**Minsmere Levels Stakeholders Group,
Stop Sizewell C and
Theberton and Eastbridge Parish Council
Issue Specific Hearing 7 (Parts 1 & 2)
Oral Contribution by Cllr. Paul Collins**

Biodiversity and Ecology

i. the SSSI crossing

SECTION B - B
SCALE 1:200

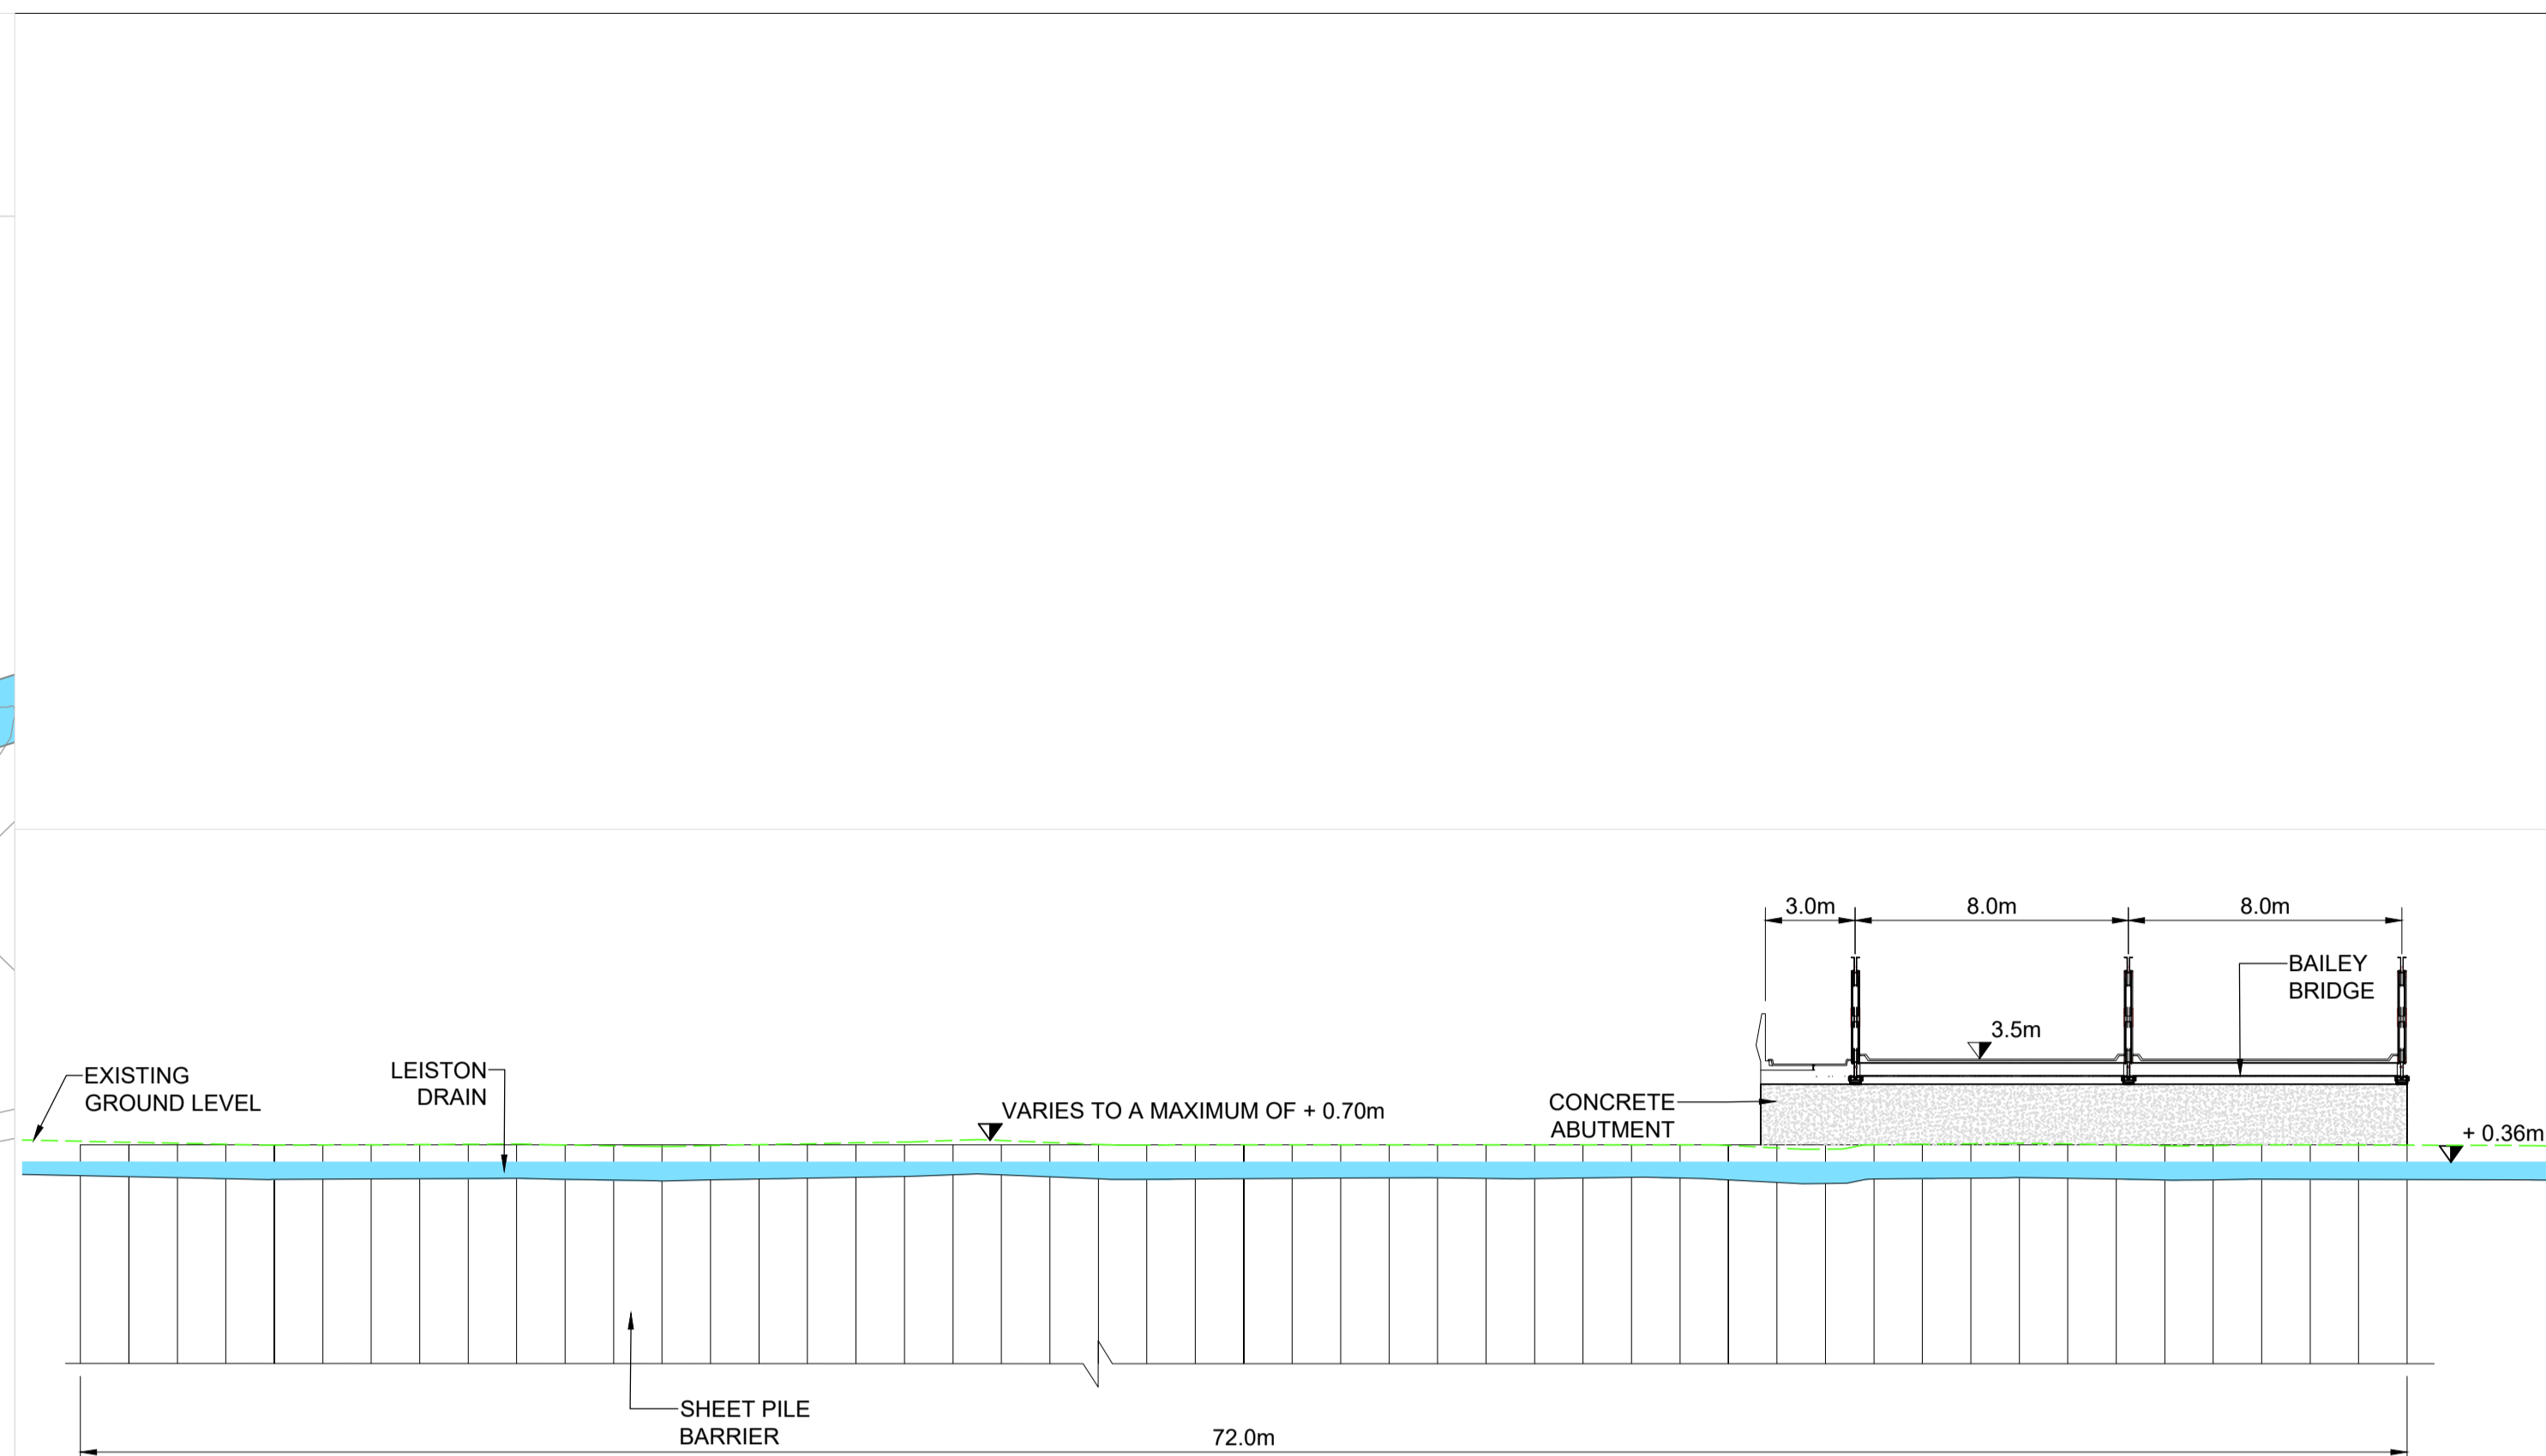
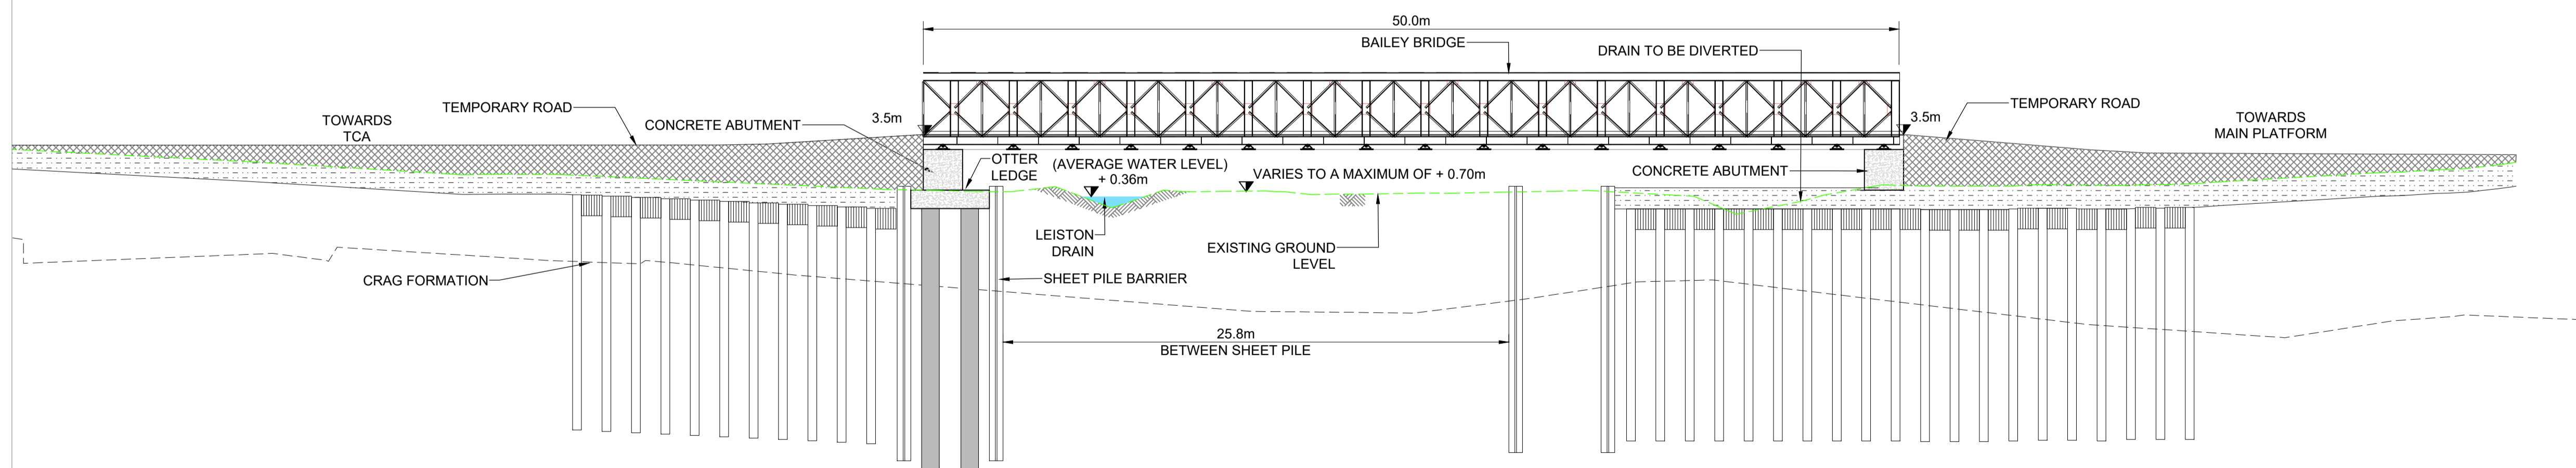
- I would echo what the previous speakers have said about the three-span bridge, we've always felt that that was the most appropriate option for a bridge across the SSSI. It has the least impact, and it would seem to have the least land take.

- The other issue that we have with the with the current design, and to an even bigger extent with the previous narrow culvert, is the fact that this is completely surrounded by sheet pile, and also then strengthened within it. The potential damage to groundwater movement through that part of the SSSI could be quite substantial.

- I know that some of the experts that we have been working with, through Suffolk Coastal Friends of the Earth, have said one of the things they were concerned about is not that water can get held up, it could actually speed up drainage beneath the culvert and start to dry out the SSSI.

- So that is the other concern that the groundwater effects are not as straightforward as they might seem to be. I would defer then to Dr Rob Lowe and Suffolk Coastal Friends of the Earth who lead on that particular set of assessments.
